Lucy Taylor
Kirklees Metropolitan Borough Council
Development Management

Our ref: RA/2024/147668/02-L01
Your ref: 2024/90548

ERECTION OF VETERINARY SURGERY (USE CLASS E) AND ASSOCIATED WORKS INCLUDING THE FORMATION CAR PARKING AND LANDSCAPING (AMENDED PLANS RECEIVED 22/05/25). FORMER RIVERSIDE WORKS, HONLEY, HOLMFIRTH, HD9 6PW

C1098 102 Rev 4	
TITLE	PROPOSED DRAWING SITE LAYOUT PLAN BOUNDARY TREATMENTS
SCALE	1:250 @ A1; 1:500 @ A3

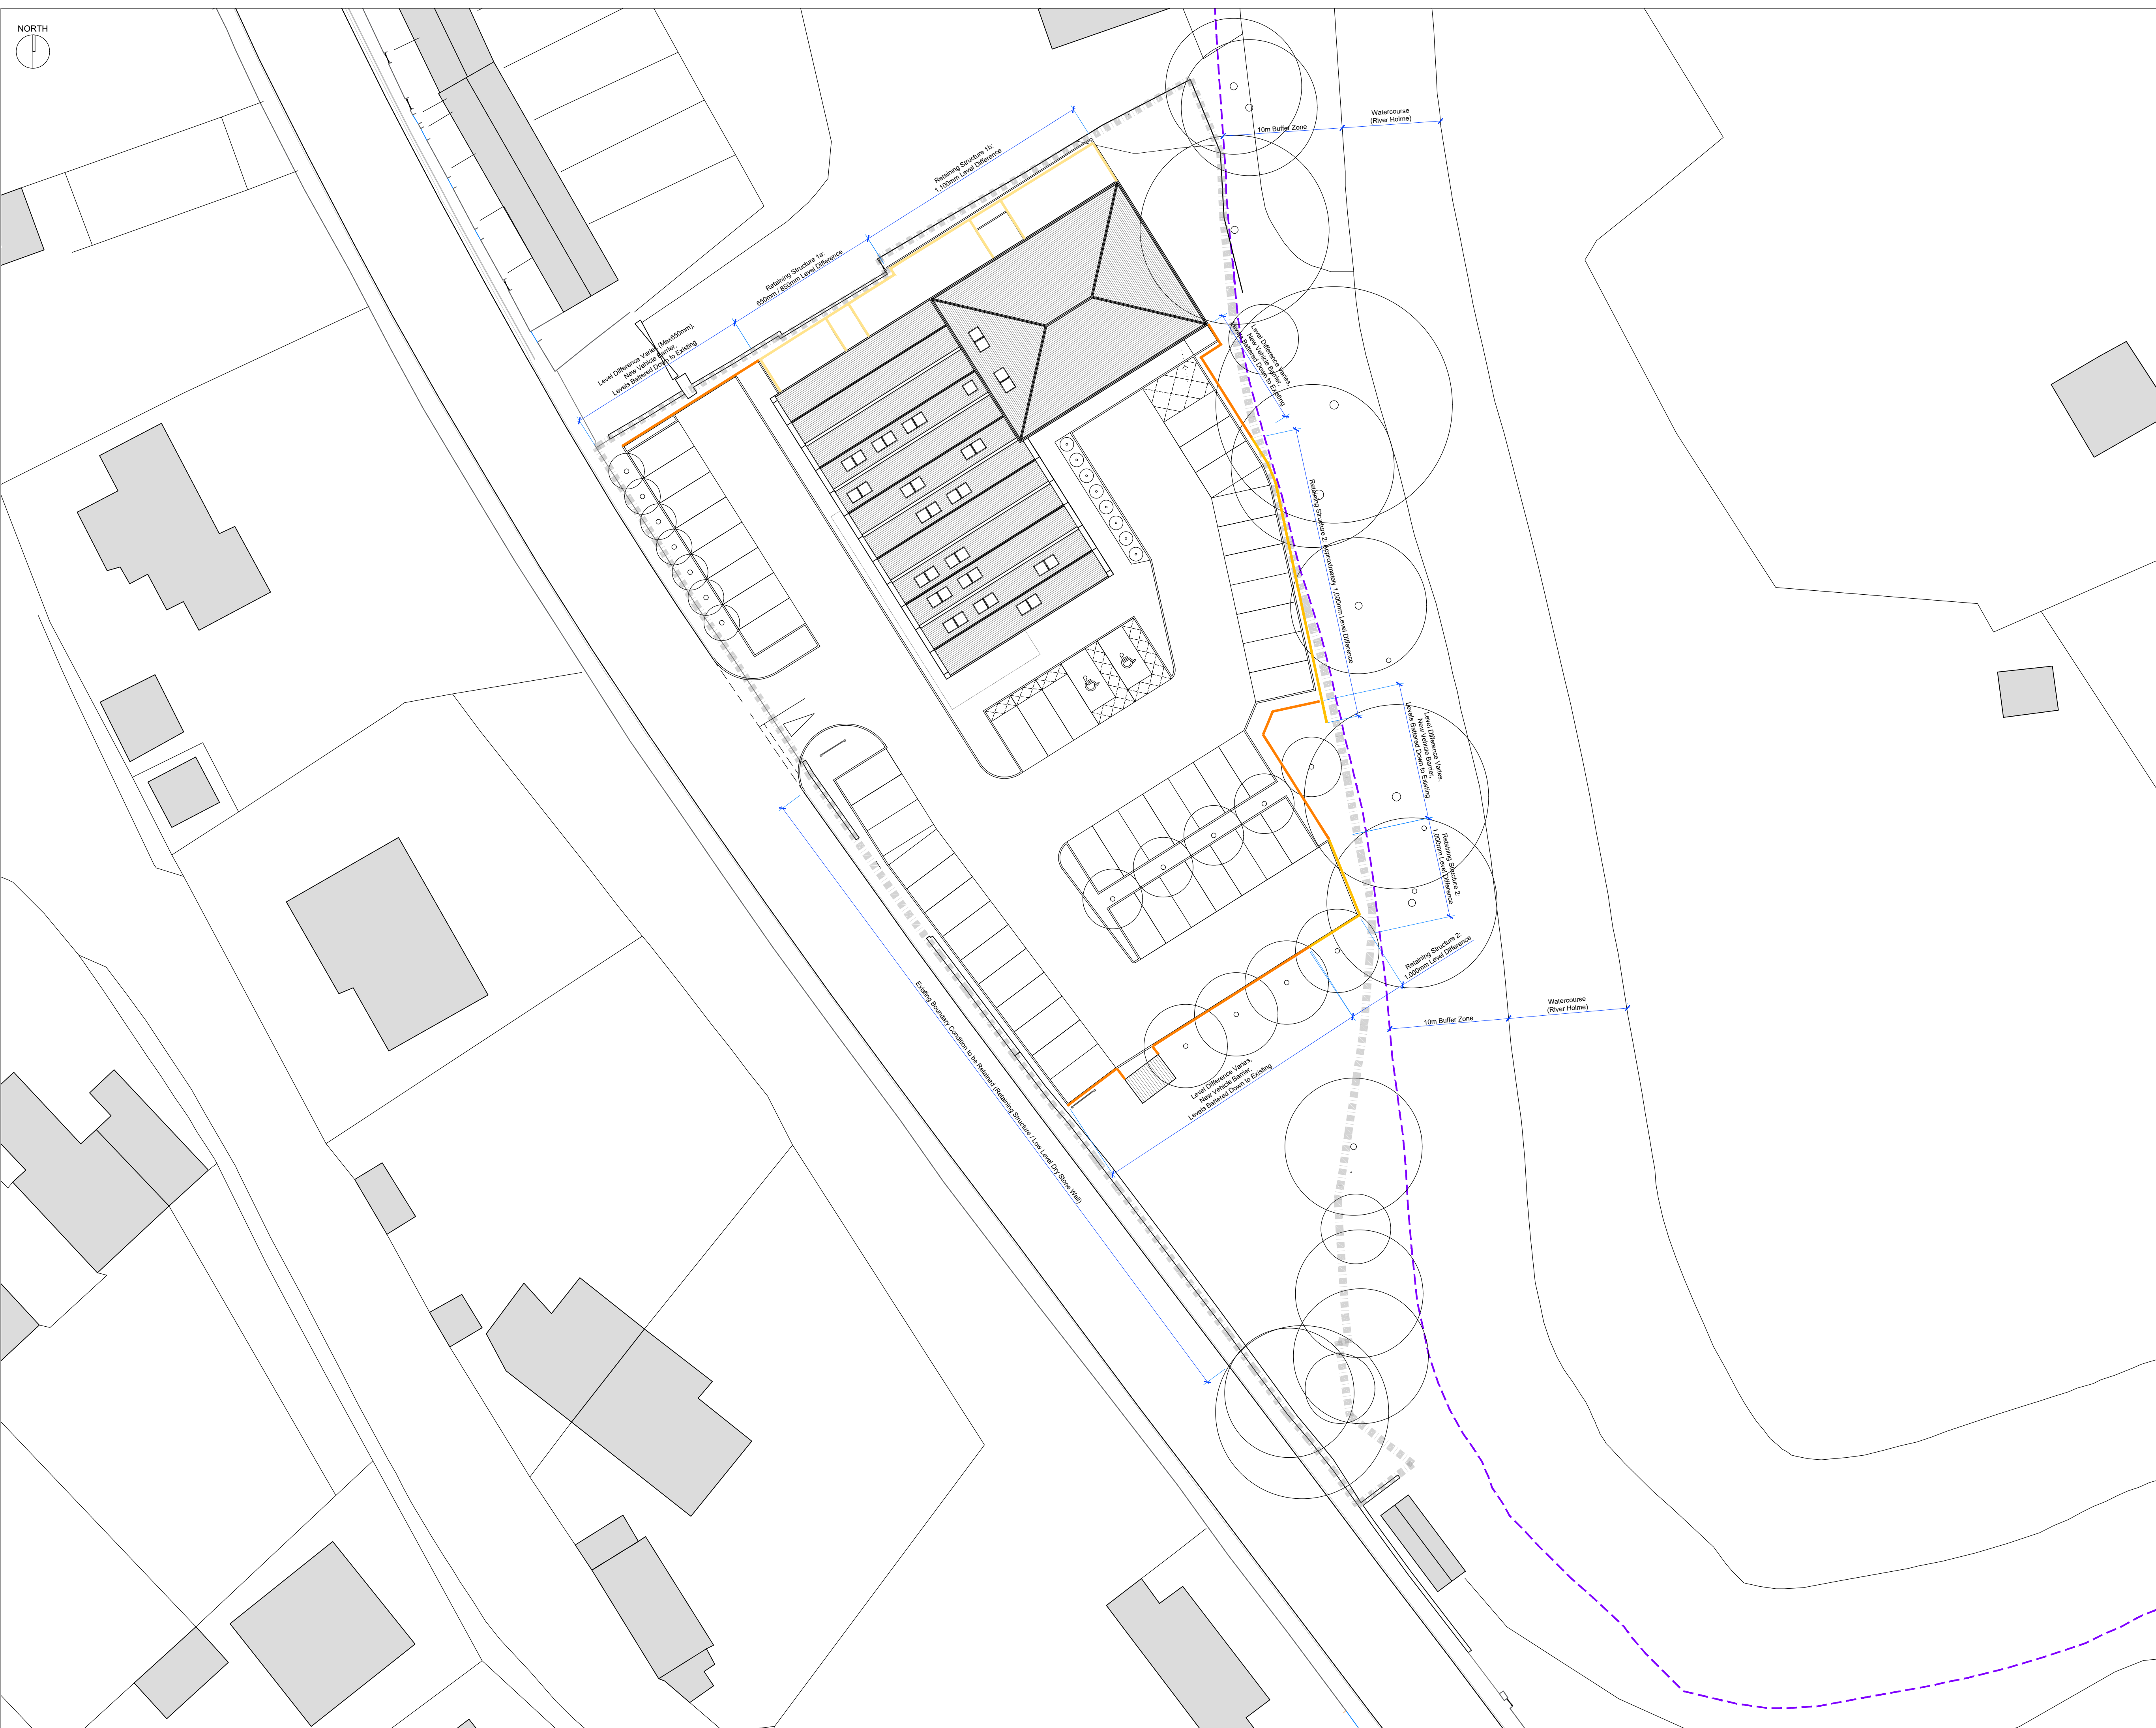
We have reviewed the information available on the planning file and wish to retain the condition we previously requested that “No development shall take place until a scheme for the provision and management of a 10-metre-wide buffer zone alongside the river Holme has been submitted to, and approved in writing by, the local planning authority.”
